Advice on Environmental Impact Statement – Hunter Street Over West Over Station Development – SSD-46246214

Thank you for your correspondence dated 2 December 2022 inviting the City of Sydney (the City) to comment on the Environmental Impact Statement submitted for the Concept State Significant Development Application (SSDA) relating to the Over Station Development (OSD) at Hunter Street West.

71. Ground Floor Plan

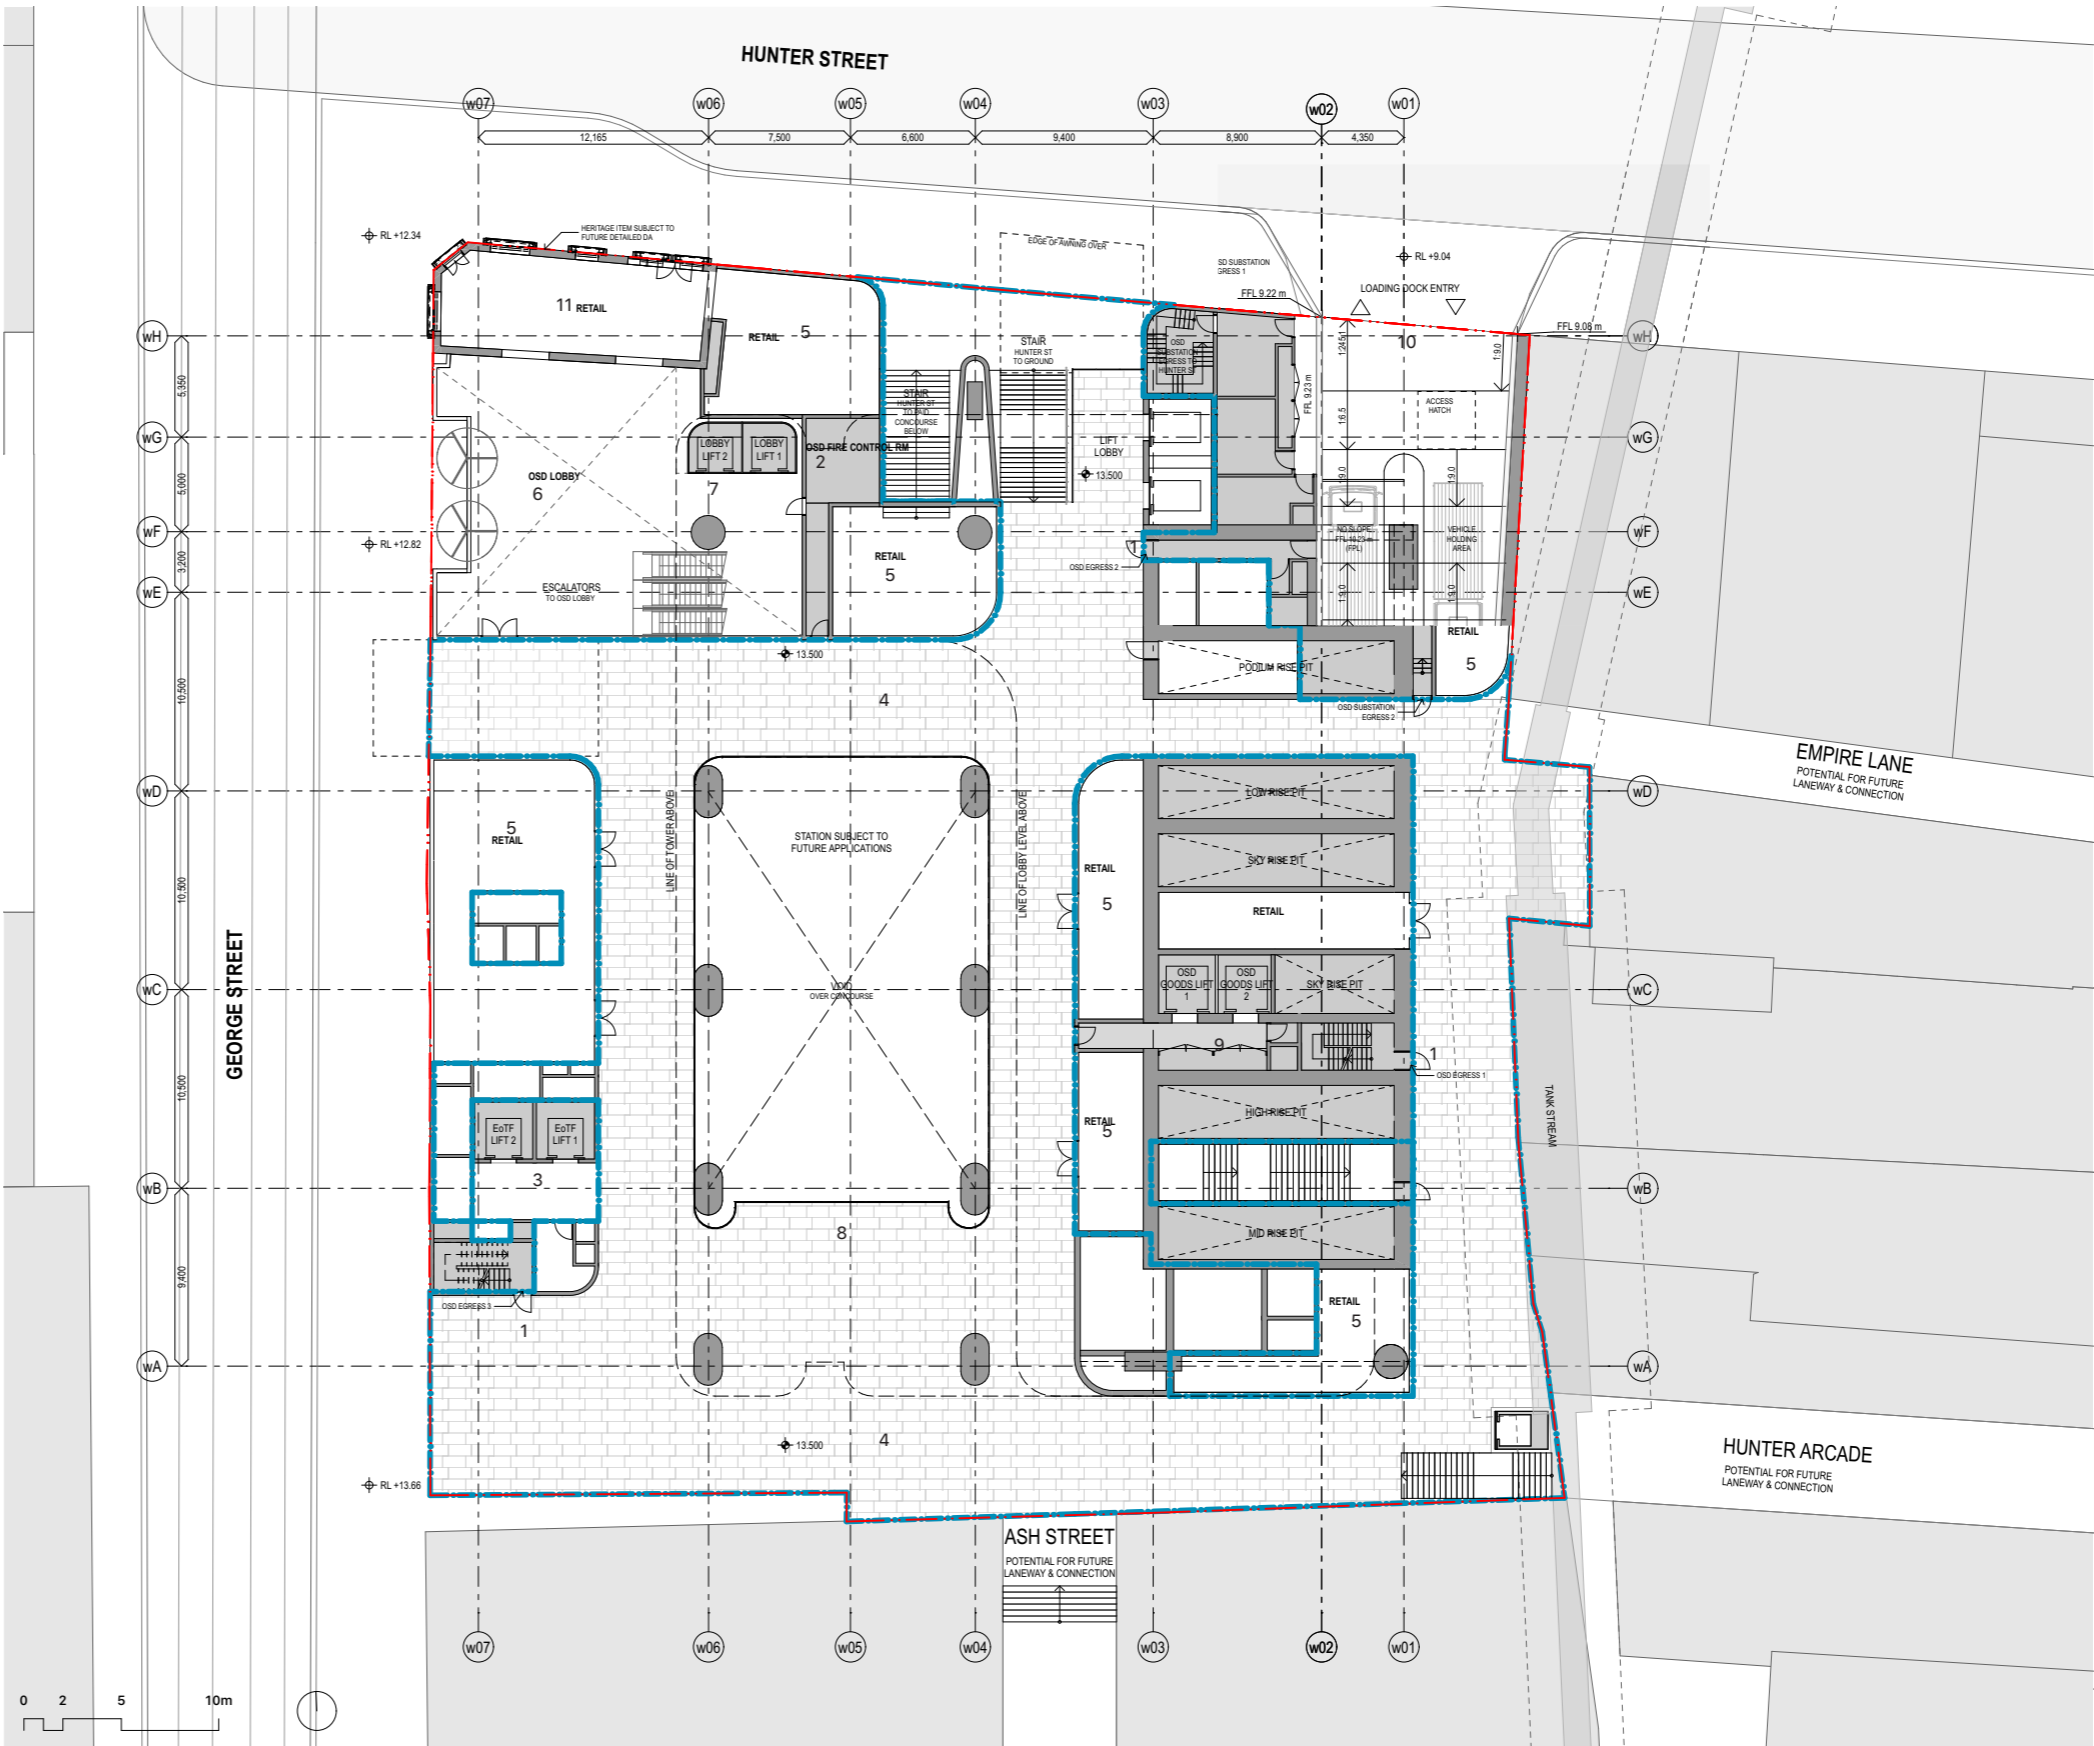
The reference design shows a two-way driveway crossing the Hunter Street footpath, with very wide splayed kerbs. Any driveway should be perpendicular to the kerb to minimise impact on the pedestrian footpath. The drawings also need to be updated to reflect the closure of Hunter Street at George Street i.e. left turns out of the driveway are not required.

The reference design shows a through-site link along the eastern site boundary which has very little active frontage to provide natural passive surveillance of the space. Any publicly accessible area should have good visibility and activation in line with CPTED principles. While it is acknowledged that this is a reference design, the location of the core is constrained by the station box and tower envelope and therefore the activation and CPTED impacts of this need consideration at the concept design stage.

The three storey building at 15-17 Hunter Street, known as Pangas House, is pending imminent heritage listing. The reference design shows a large driveway immediately next to this building. The scale of the driveway is not sympathetic to the fine grain and low scale of the neighbouring heritage buildings and the historic character of Hunter Street. It is also not consistent with the following point in the draft Guidelines associated with the Planning Proposal:

- *6. Vehicle access and egress is to be designed as a single lane crossing the footpath with a maximum width of 3.6 metres and designed to ensure any queuing is contained internally within the site, so vehicles do not queue across footpaths.*

A driveway following this guideline will considerably reduce the vehicle entry's visual impact on the streetscape and adjacent heritage buildings. The City recommends that this guideline be followed.
